SUBJECT: BRES2206-0009
BUILDING RESIDENTIAL

Here are the results of all Inspections located at **347 FOREST DR:**

A - 10 x 14 x 3
wood deck
with steps
B 4 x 6 x 3
wood deck
with steps

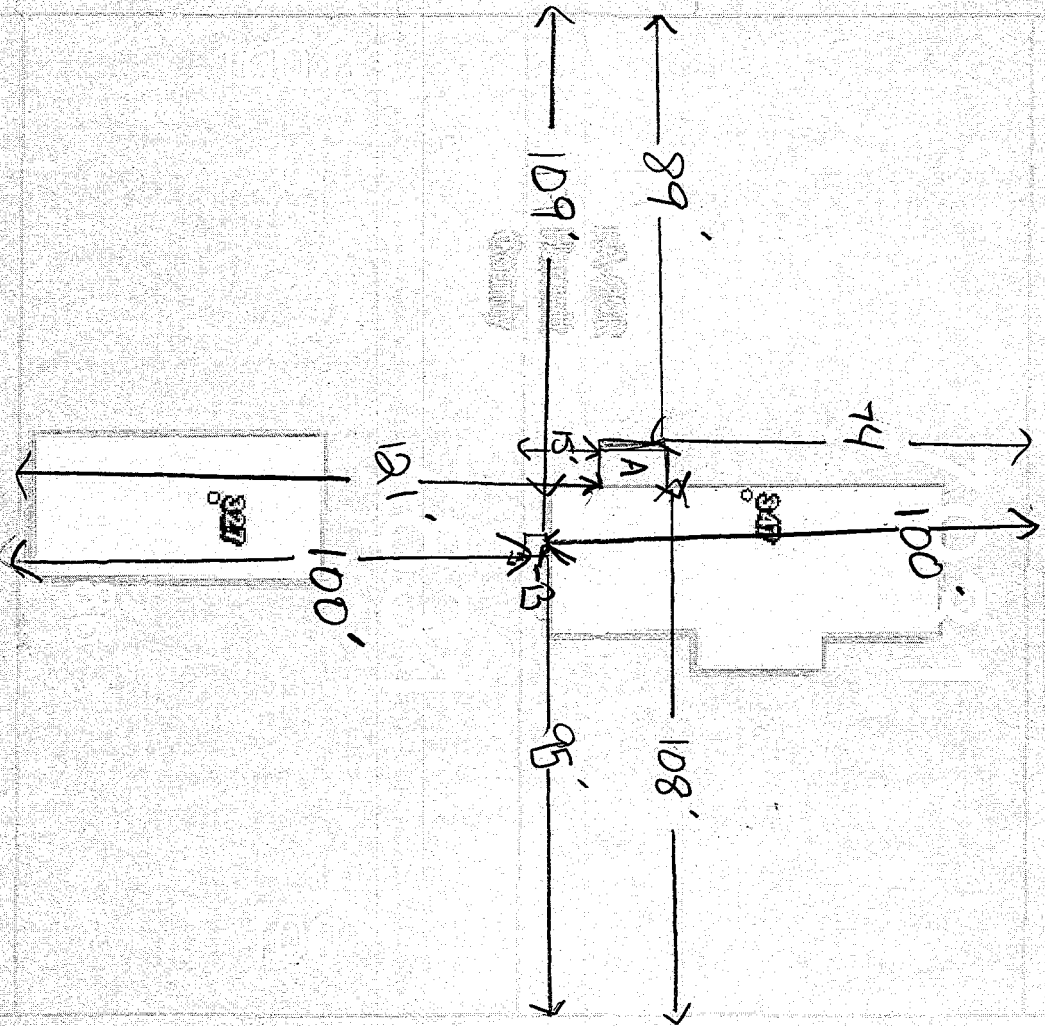
Inspection Type: FOOTING
Scheduled Date/Time: 9/2/2022
Completed Date/Time: 9/2/2022
Inspector: Steven Gazlay
Result: DISAPPROVED
Remarks:
Notes: Discussed with contractor. Provide code complaint footings. Cannot bolt deck to mfh brick skirting.

Inspection Type: FOOTING
Scheduled Date/Time: 9/7/2022
Completed Date/Time: 9/7/2022
Inspector: Steven Gazlay
Result: APPROVED
Remarks:
Notes:
